Westmead Catholic Community Education Campus (SSD-10383)
Response to Submissions

ATTACHMENT 1 – KEY ISSUES

CELC & ADMIN BUILDING
WEST ELEVATION SHADOW STUDIES

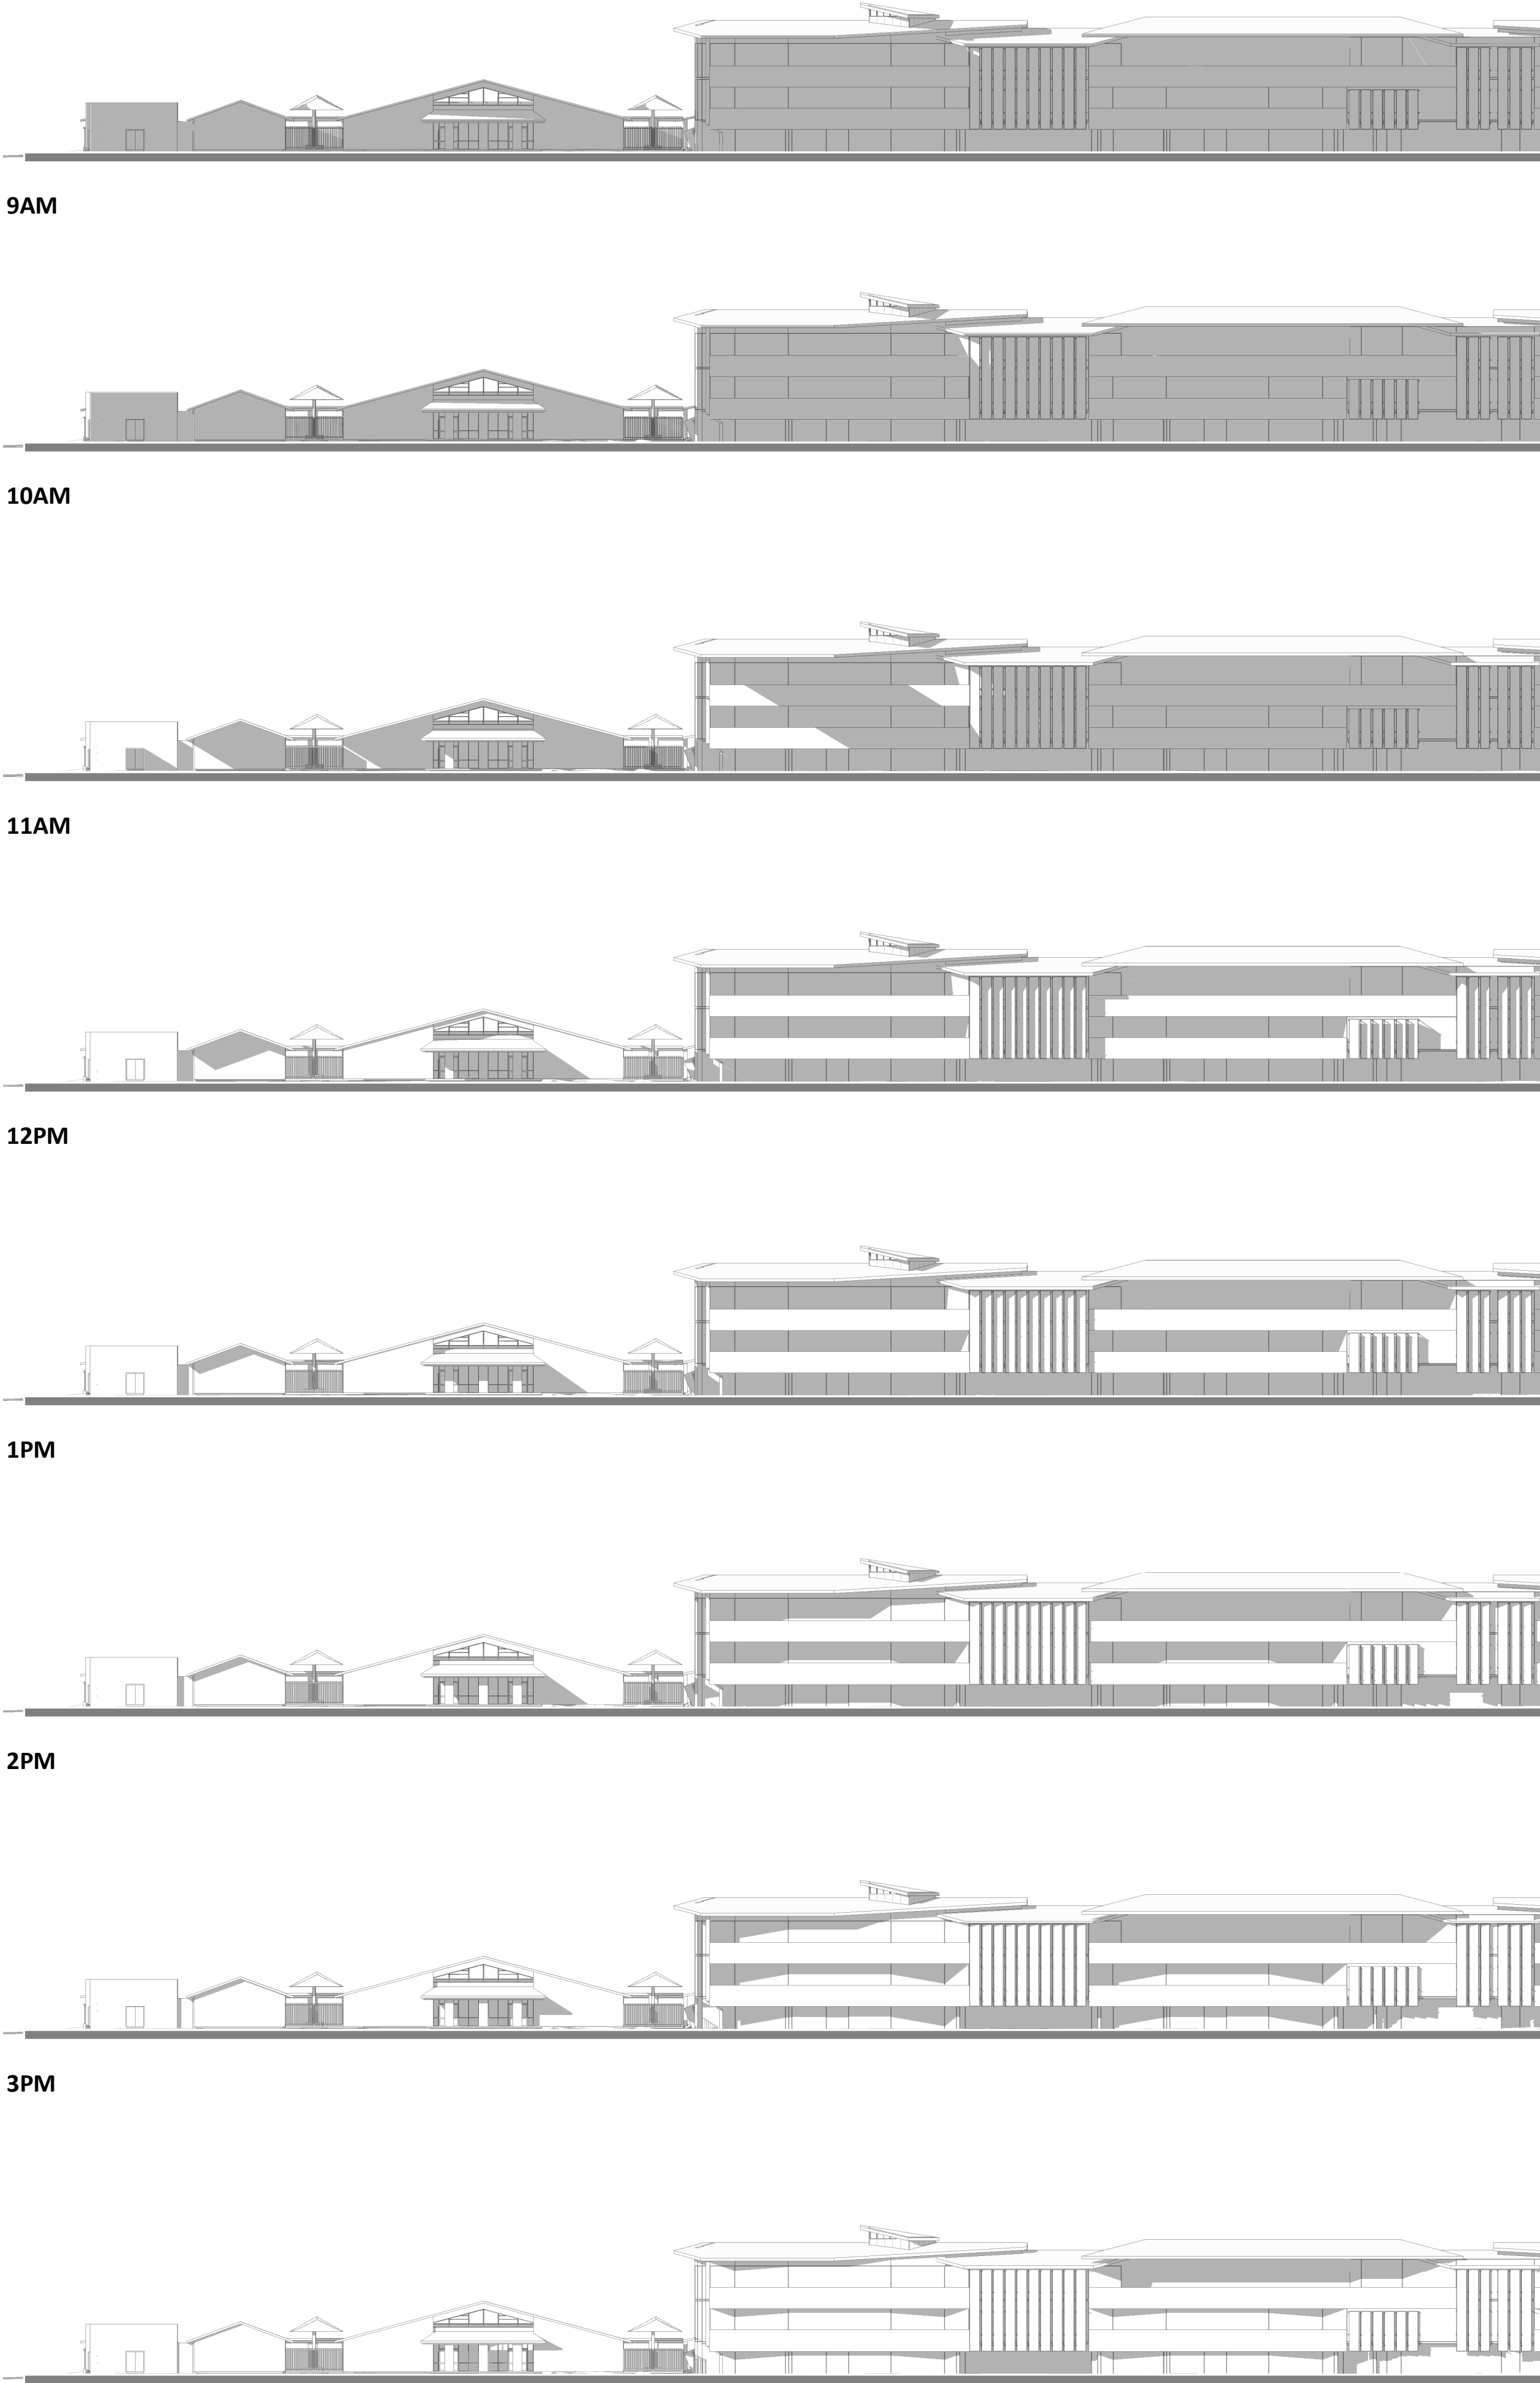
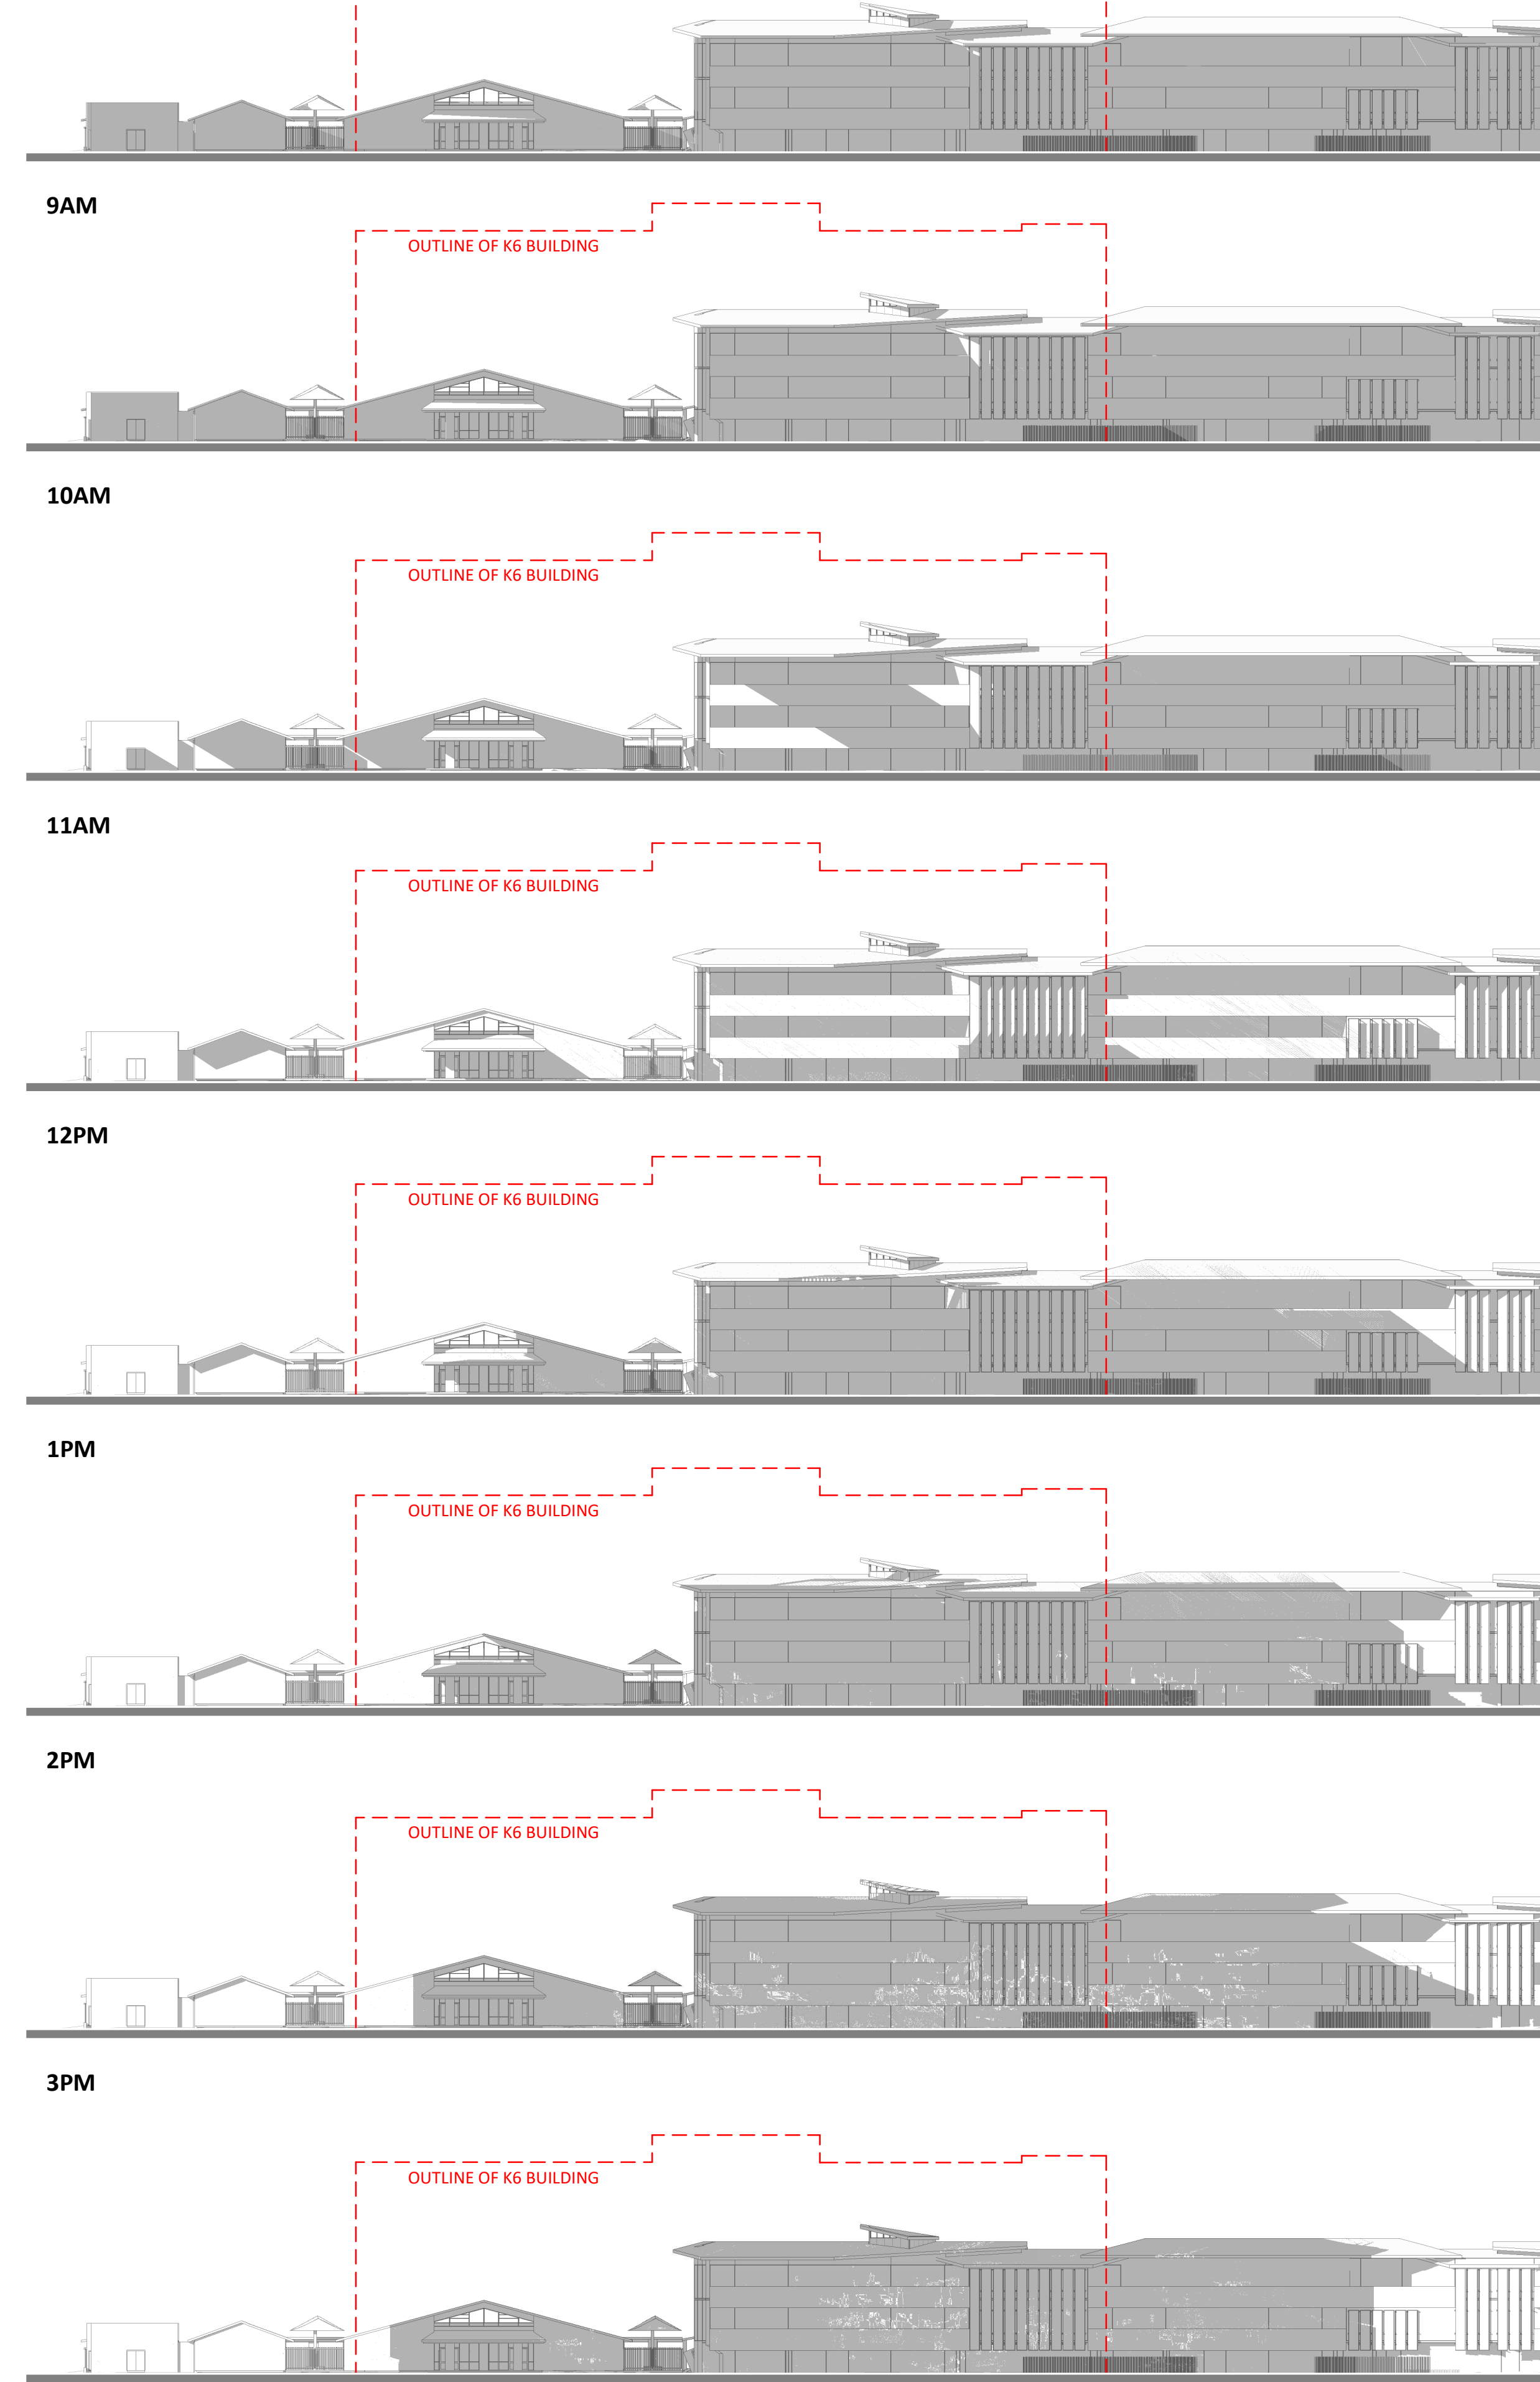
- Hourly elevational shadow diagrams are to be provided for the proposed development during the winter solstice to assess the impacts of the primary school building on the façade of the childcare centre / administrative building.
